**EXHIBITION OF ENVIRONMENTAL IMPACT STATEMENT
SUTHERLAND HOSPITAL OPERATING THEATRE UPGRADE
KINGSWAY AND KAREENA ROAD, CARINGBAH**

Thank you for referring the Environmental Impact Statement (EIS) regarding SSD-11099584 Sutherland Hospital Operating Theatre Upgrade to Transport for NSW (TfNSW).

TfNSW has reviewed the EIS and provides the following advisory comments for the Department's consideration in **TAB A**.

Appendix A – Swept Path Analysis

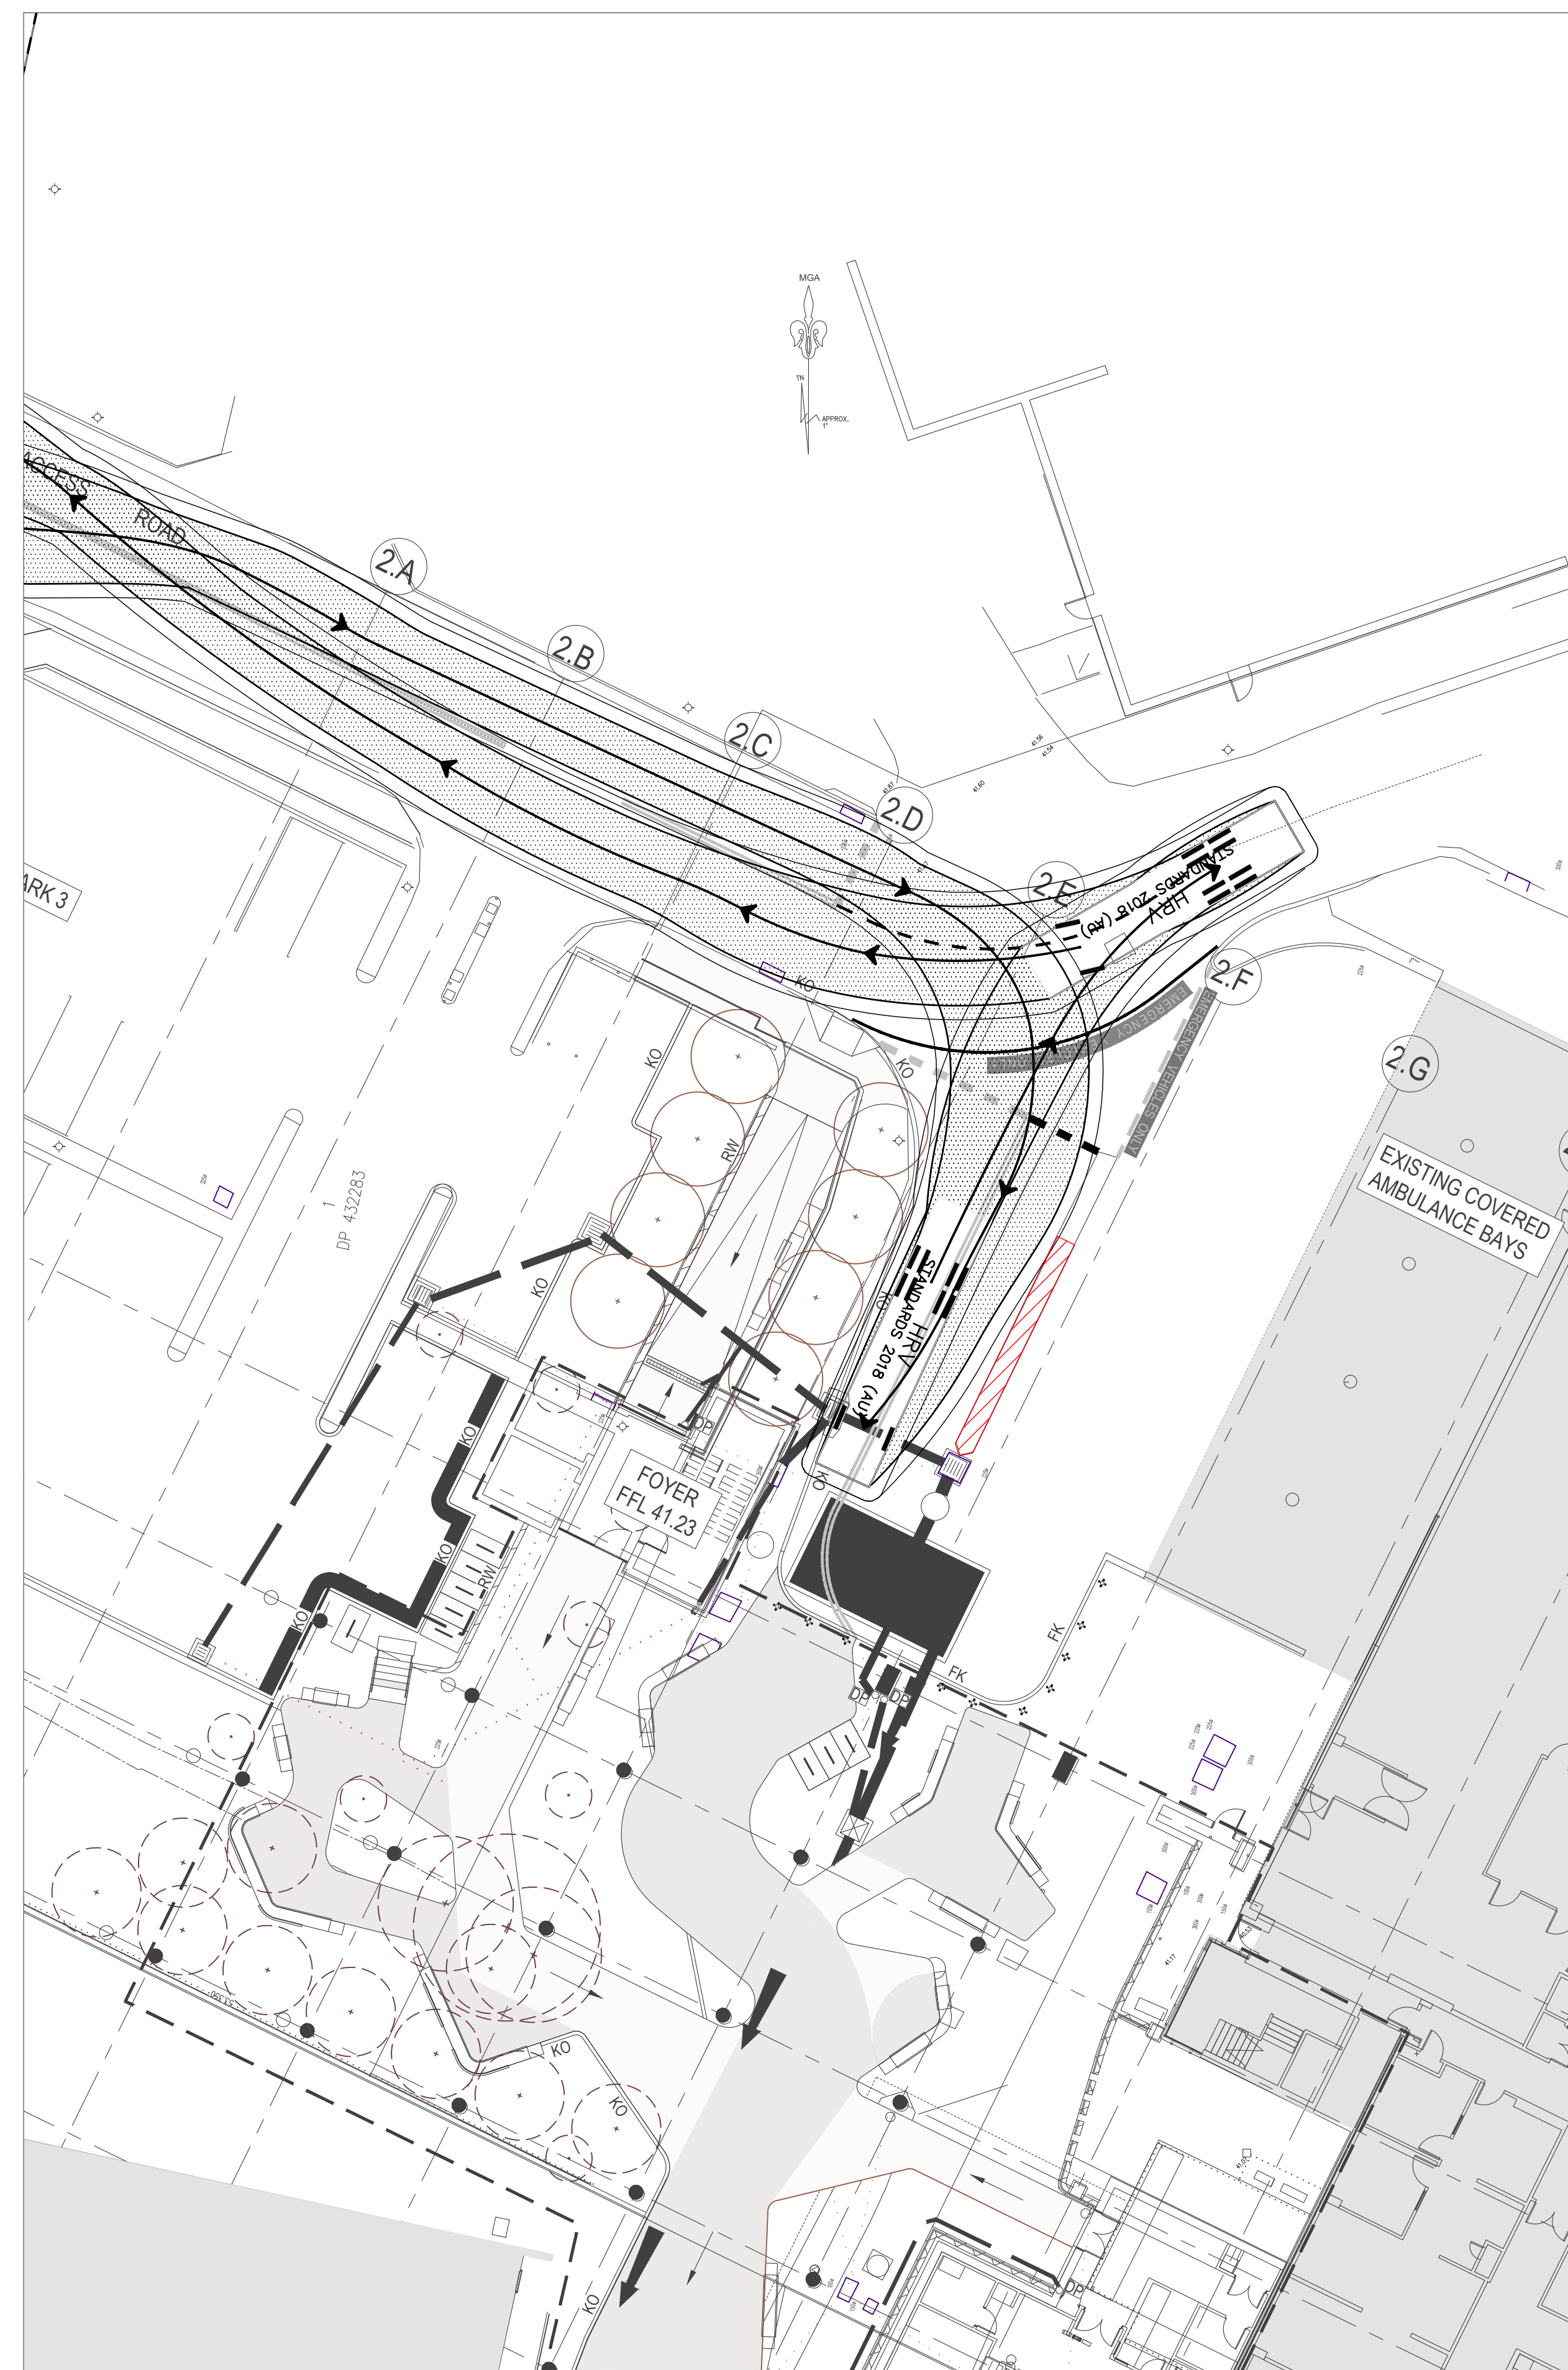
The CTMP does not indicate the largest/longest vehicle size will be needed and the frequency of this movement. Under Part 5.2 Public Infrastructure, the plan states that large vehicles may need to mount or cross public kerbs and median devices if necessary, to which the builder will account for any damages to any public infrastructure.

Details of the largest/longest vehicles accessing the site are required to be submitted as part of the Response to Submissions, as well as a swept path analysis for these vehicles accessing the site.
